Subject: RE: Y/9818/RES and Y/97/18/DOC

Thank you for supplying the revised information. I have the following comments:

Scale AS SHOWN @ A1	Date JUNE 19	Designed JA
Drawn JA	Checked LH	Approved LH
Job No 18-070	Drawing No 18-070/114	Rev C

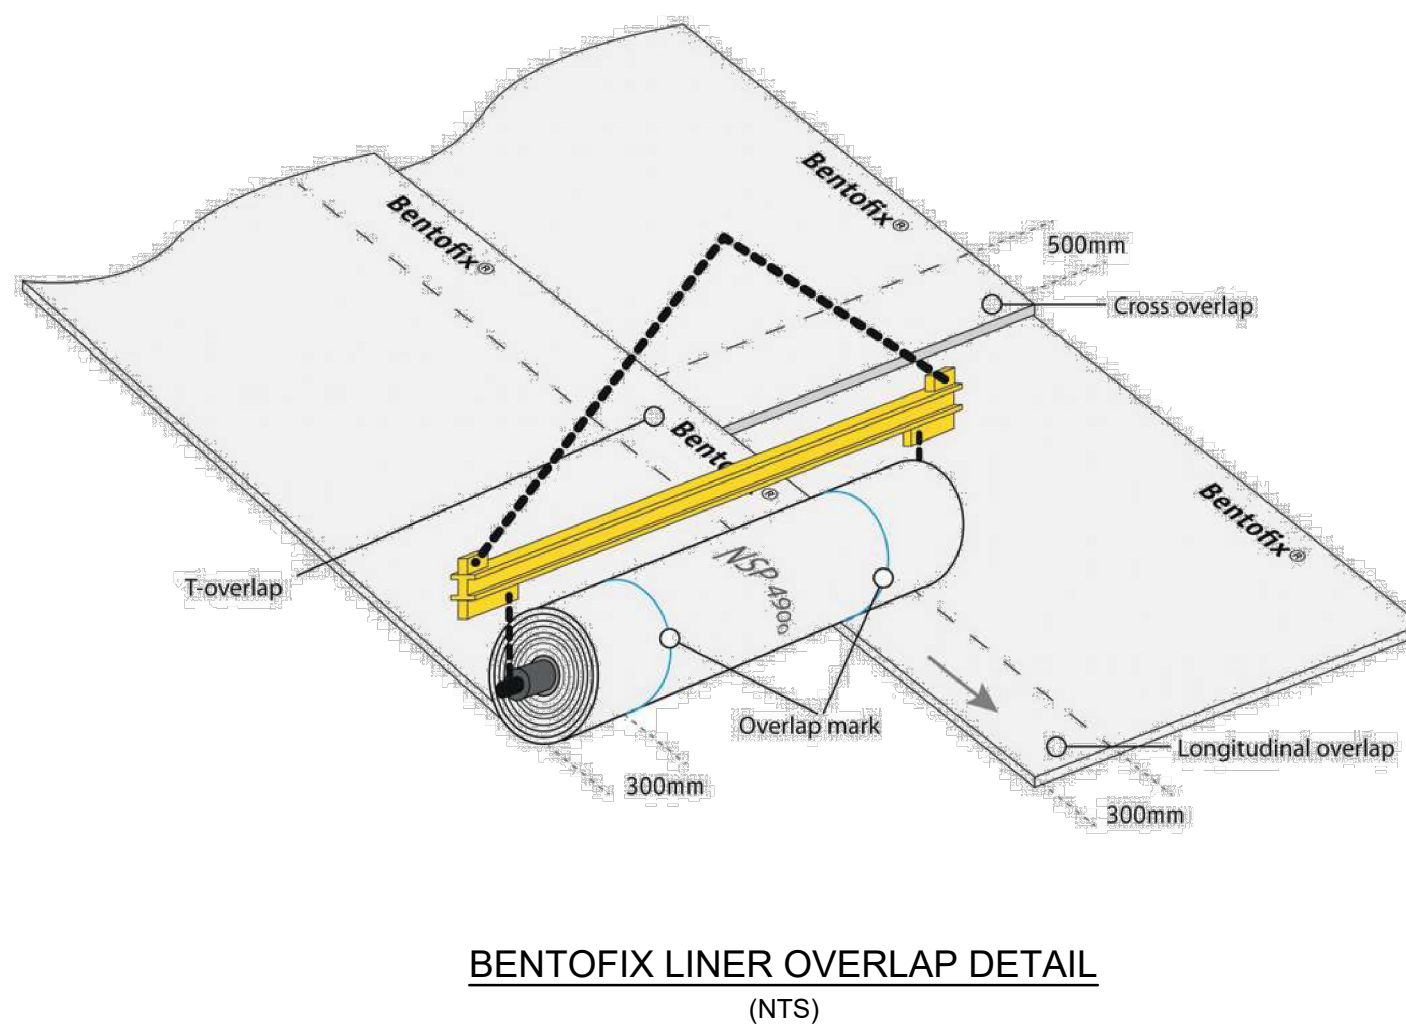
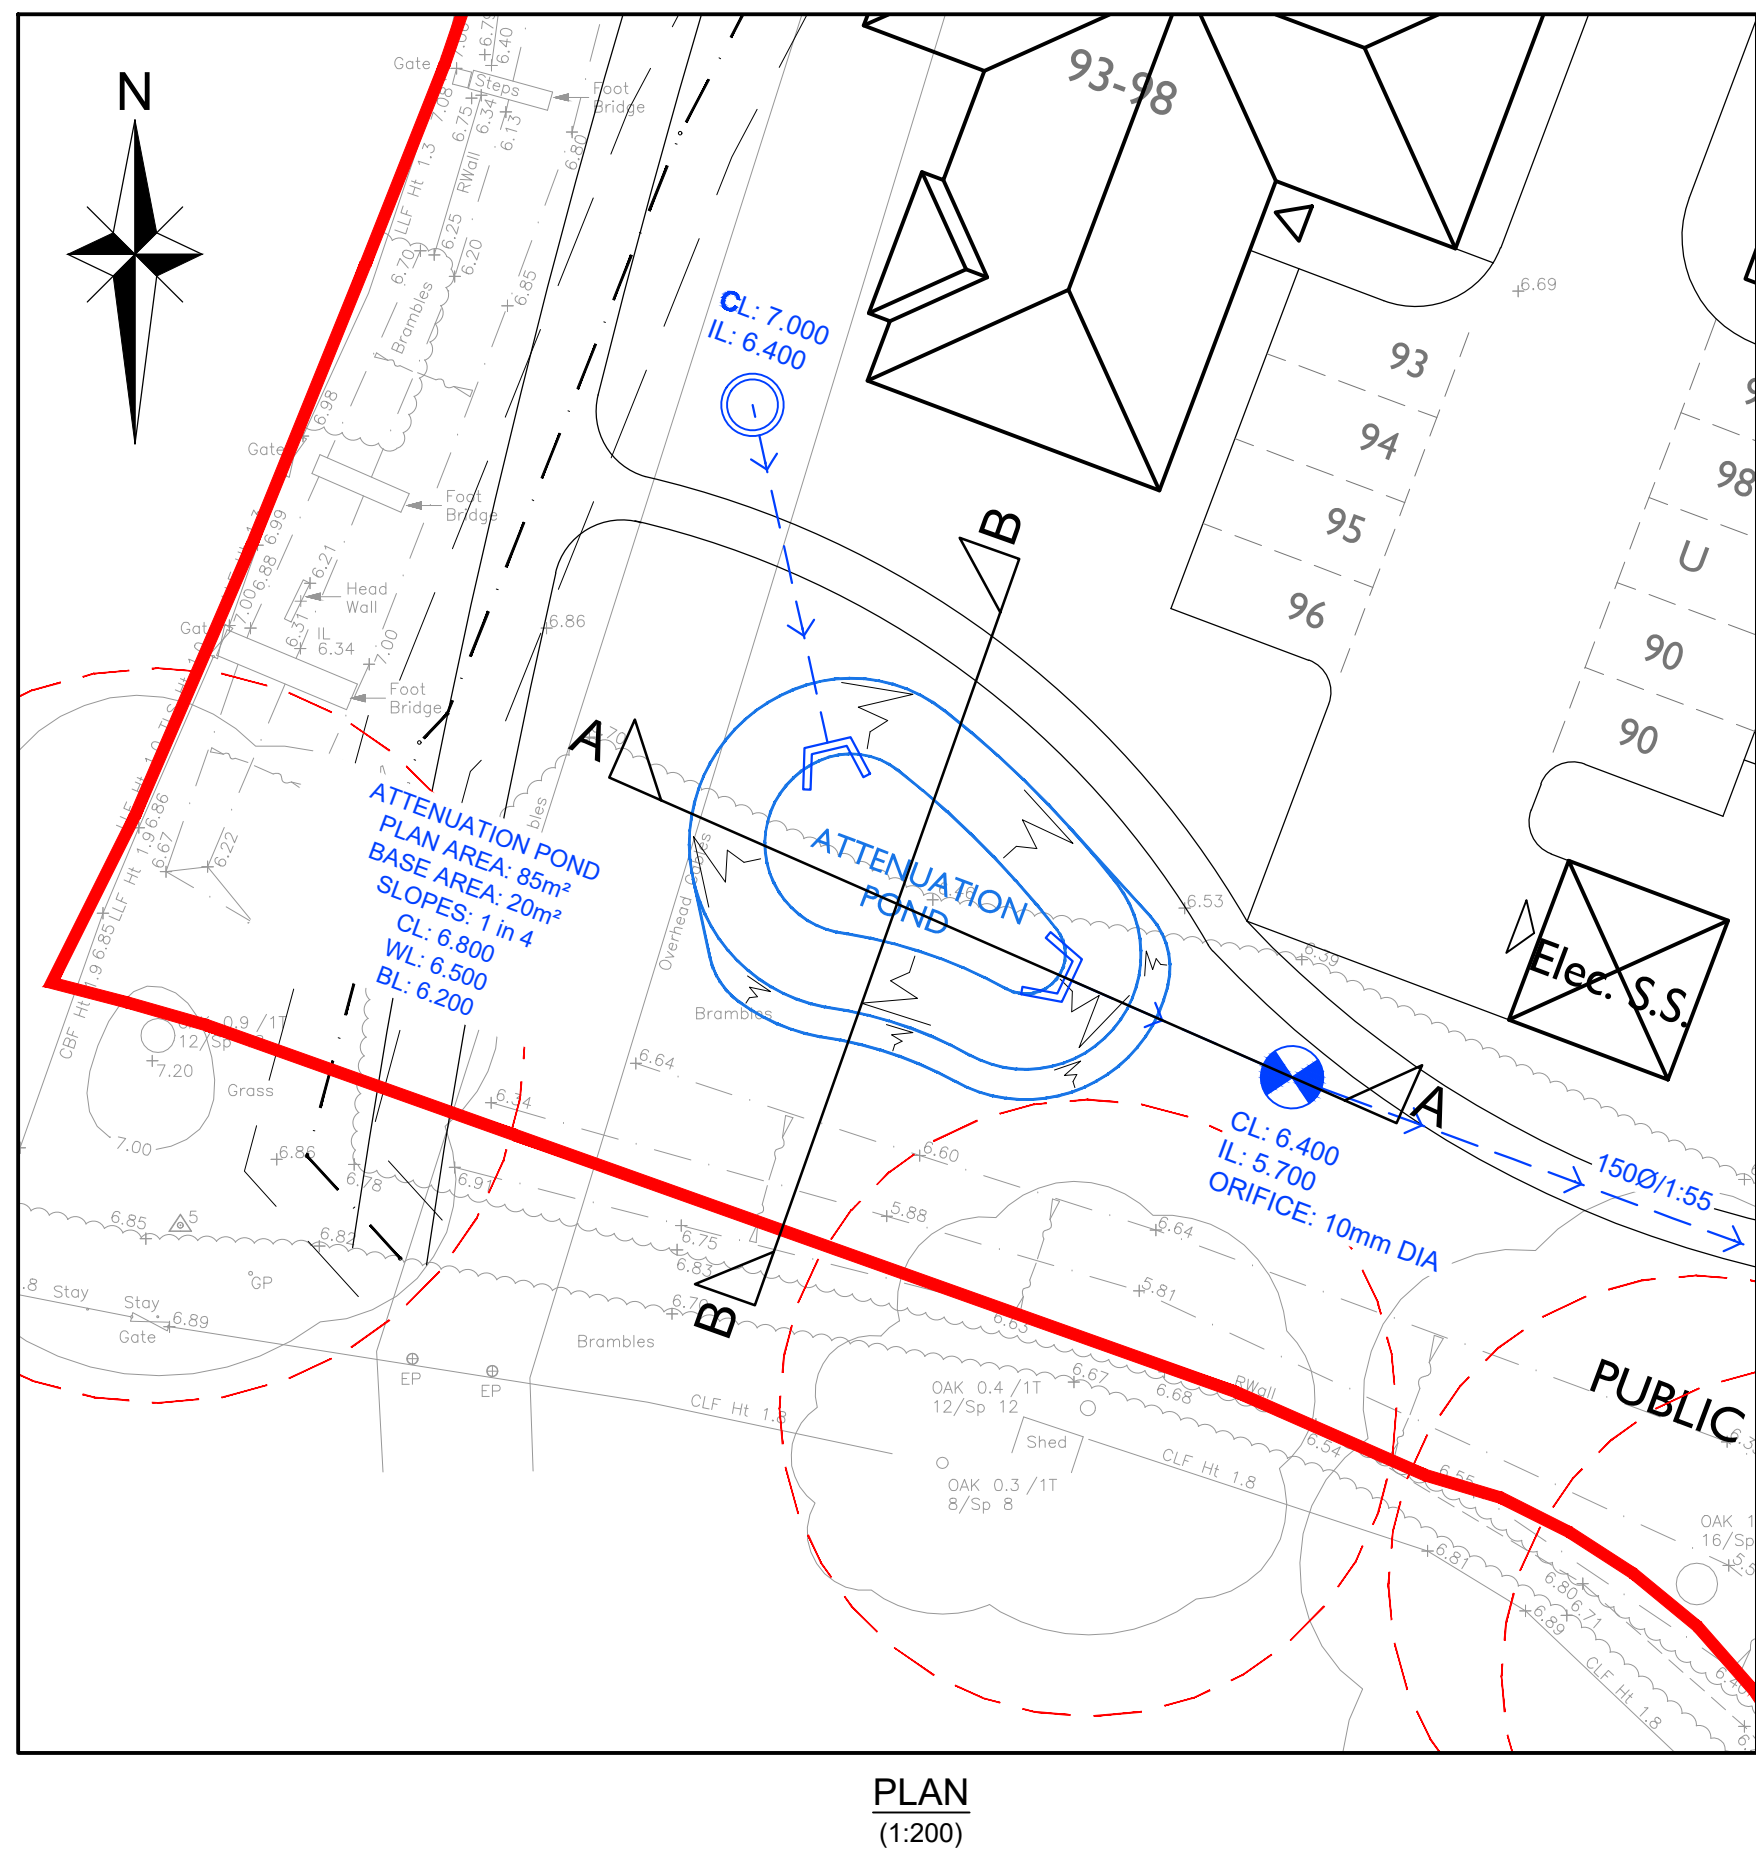
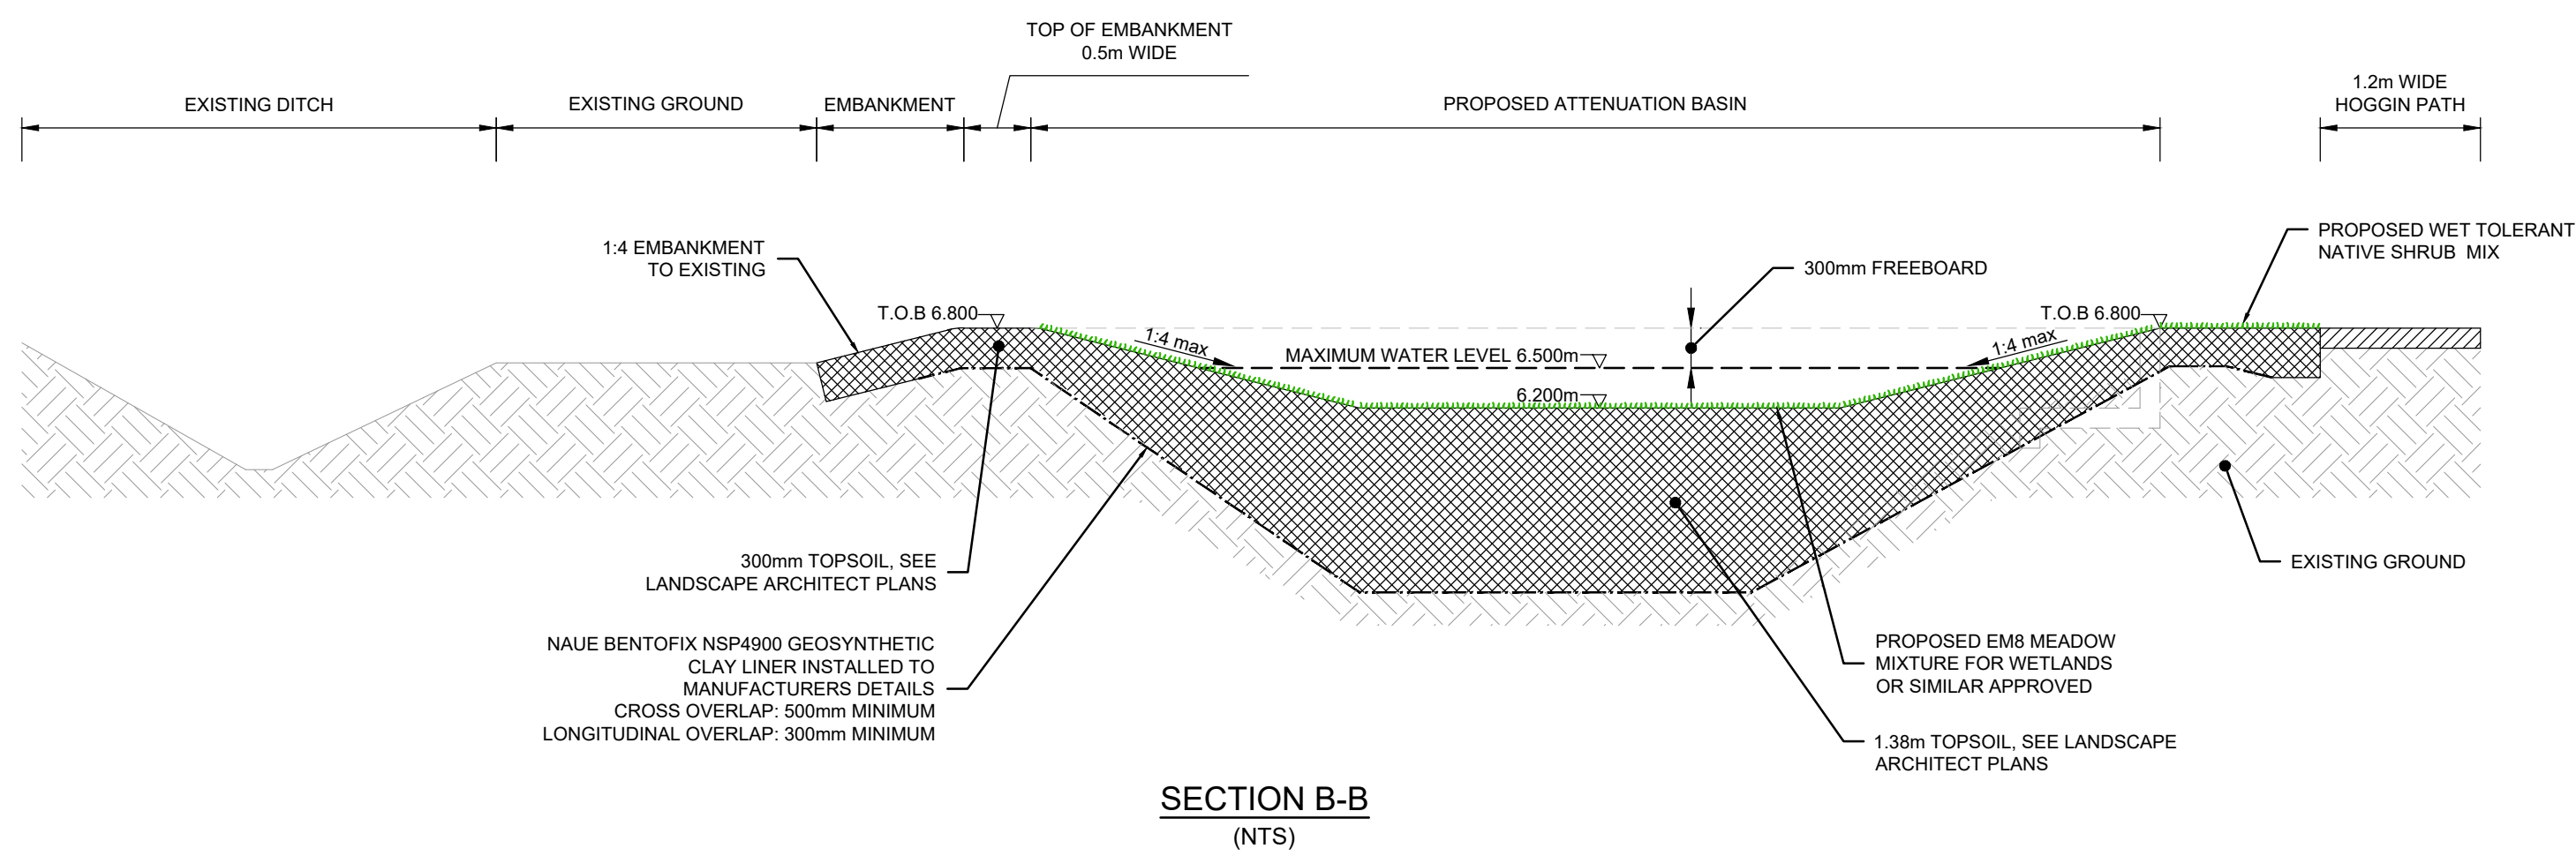
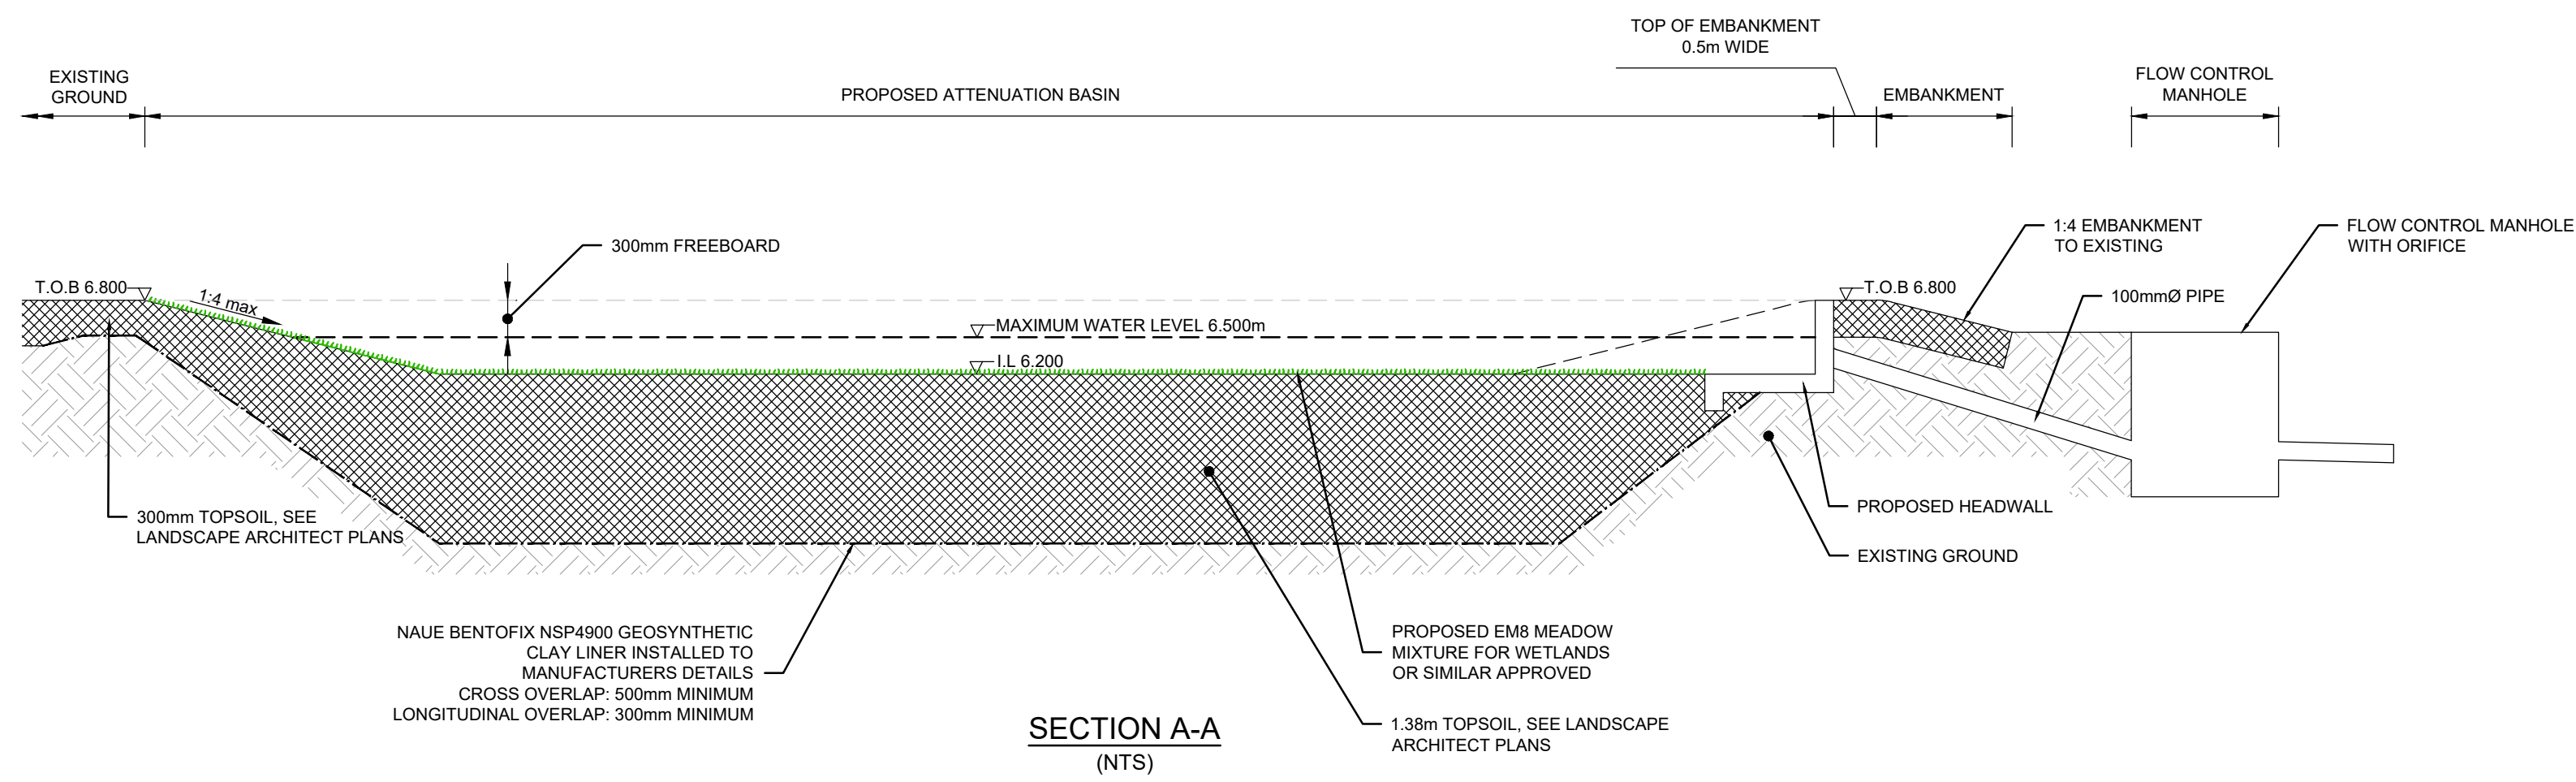
4. There are discrepancies between cover levels and invert levels of tanks in flotation calculations and on drawings.
5. Please update the construction detail drawings to show permeable geotextile wrap fully around the sub-base.

8. In some locations there are significant drops between orifice invert level and the invert level of the main surface water pipe. Please provide a detail that accurately represents this.
